Application No: BR/60/26/HH
Site Address: 71 Longford Road Bognor Regis PO21 1AE
Description of works: Retrospective application for conversion of former detached garage to form annexe, including raising of the ridgeline.

Planning application BR/60/26/HH

Proposed

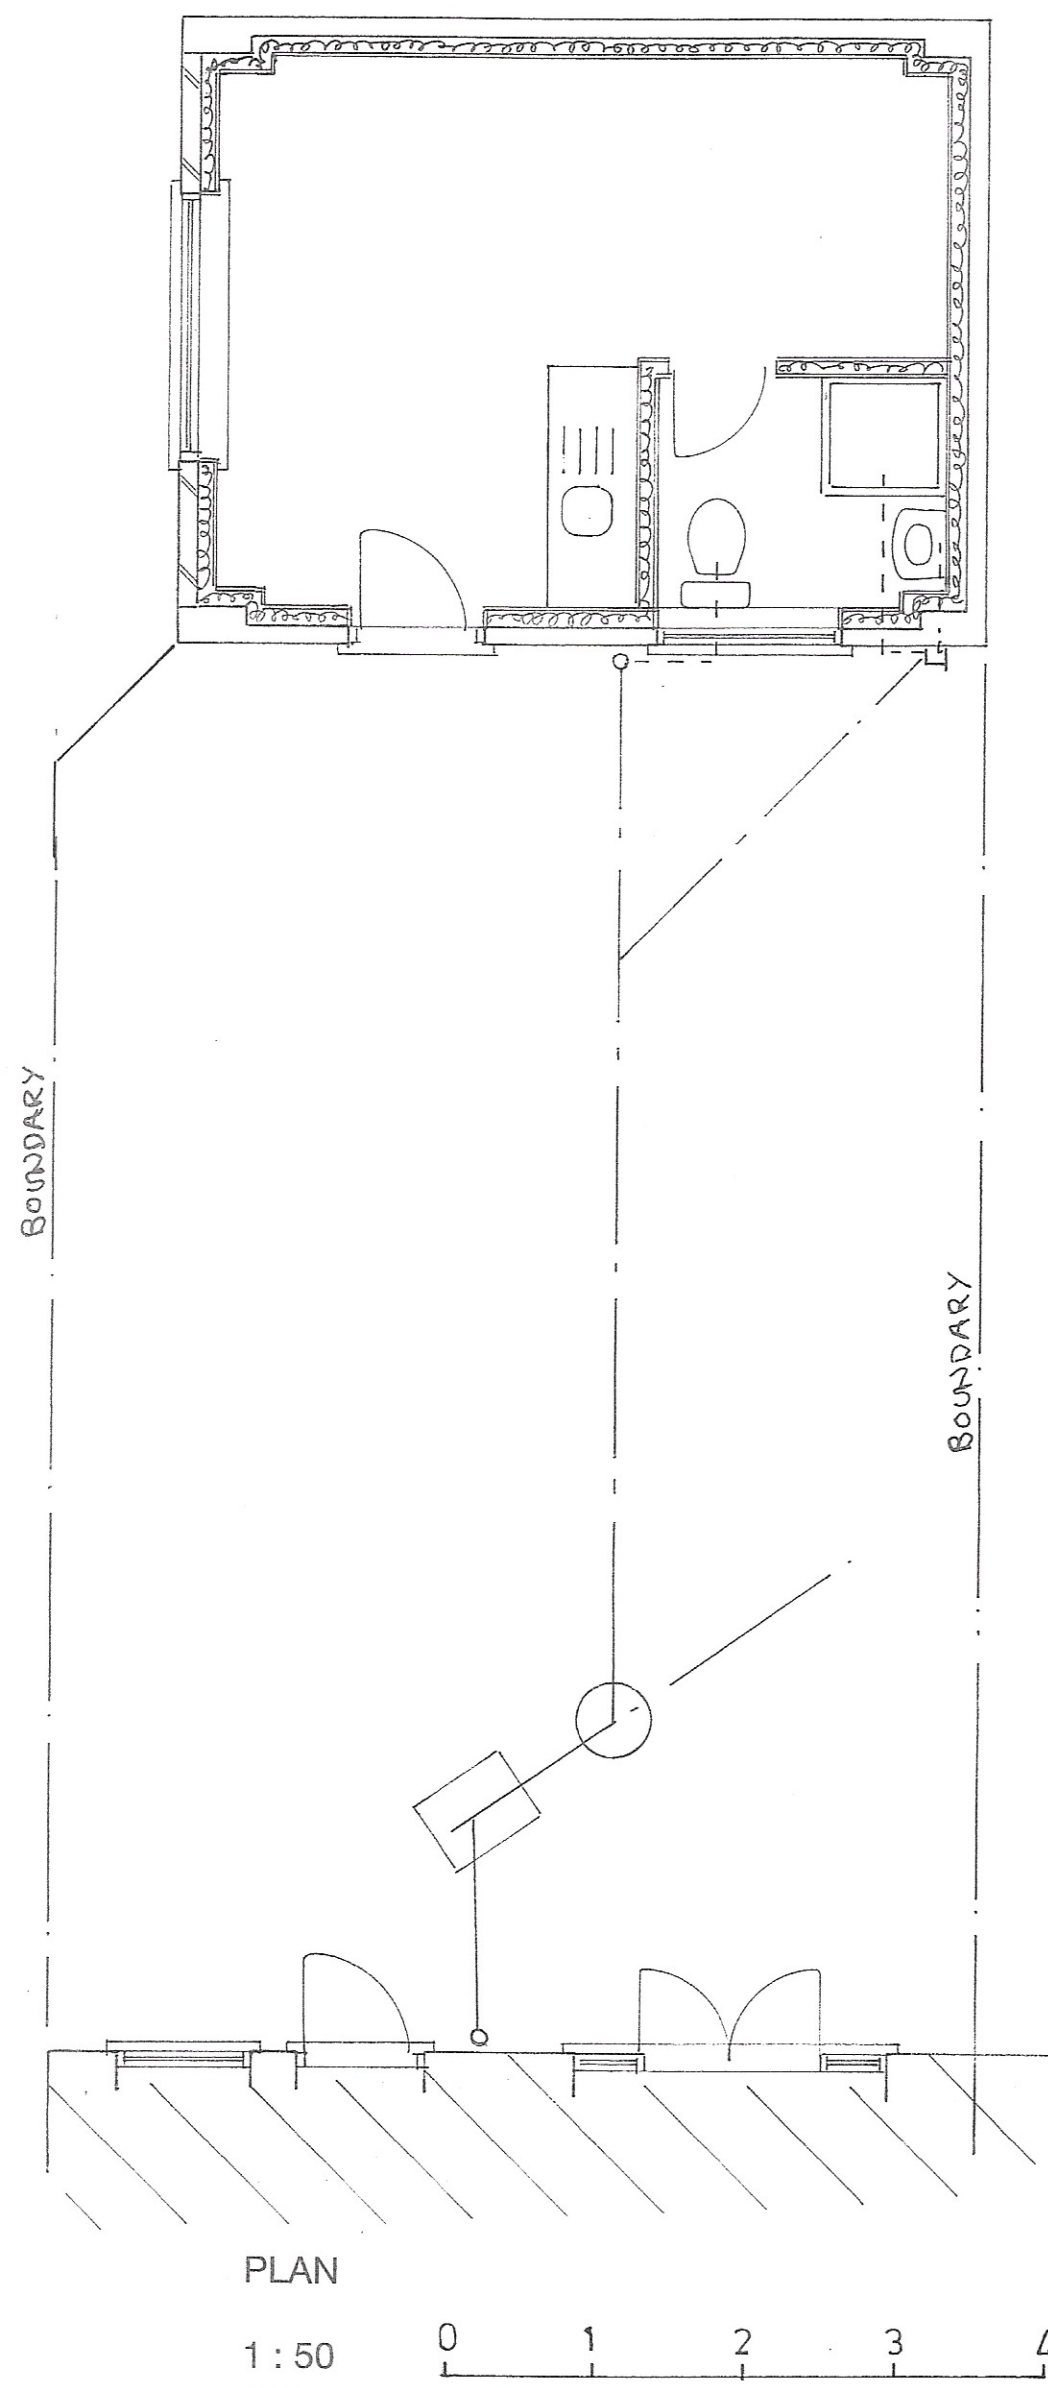
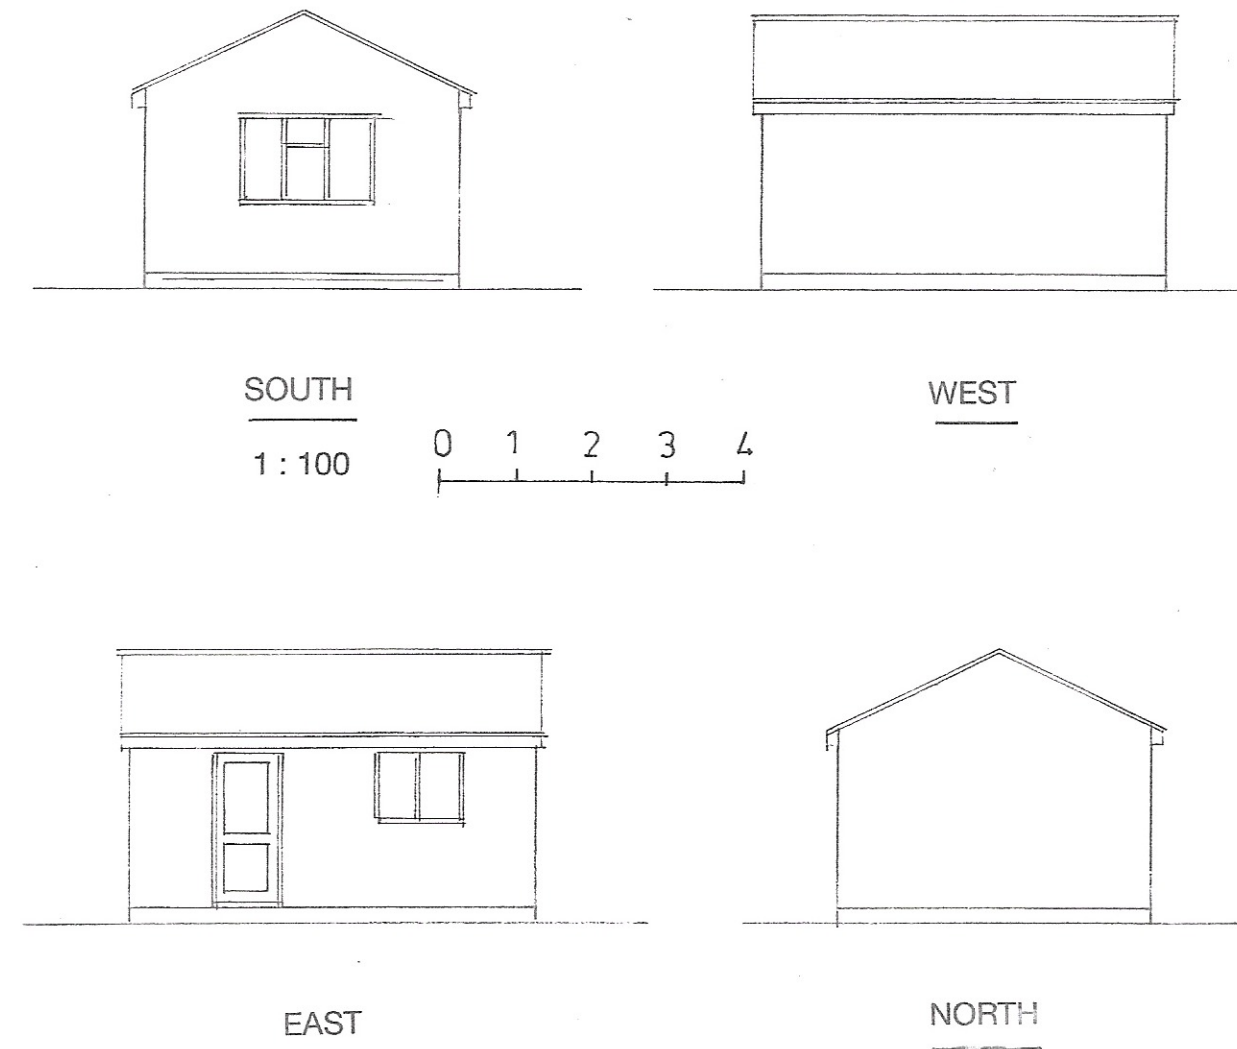
There is currently no access to the garage on the east elevation even though it has been illustrated on the plans but on the south elevation.

This access opens straight on to my private driveway which is on the south elevation where permission has not been granted.

The plans on the application do not show the mezzanine floor for the sleeping space which is currently installed within the garage and skylights are not shown on the eastern elevation.

If permission is granted then the access should be on the east elevation as per the drawings and not on the south elevation.
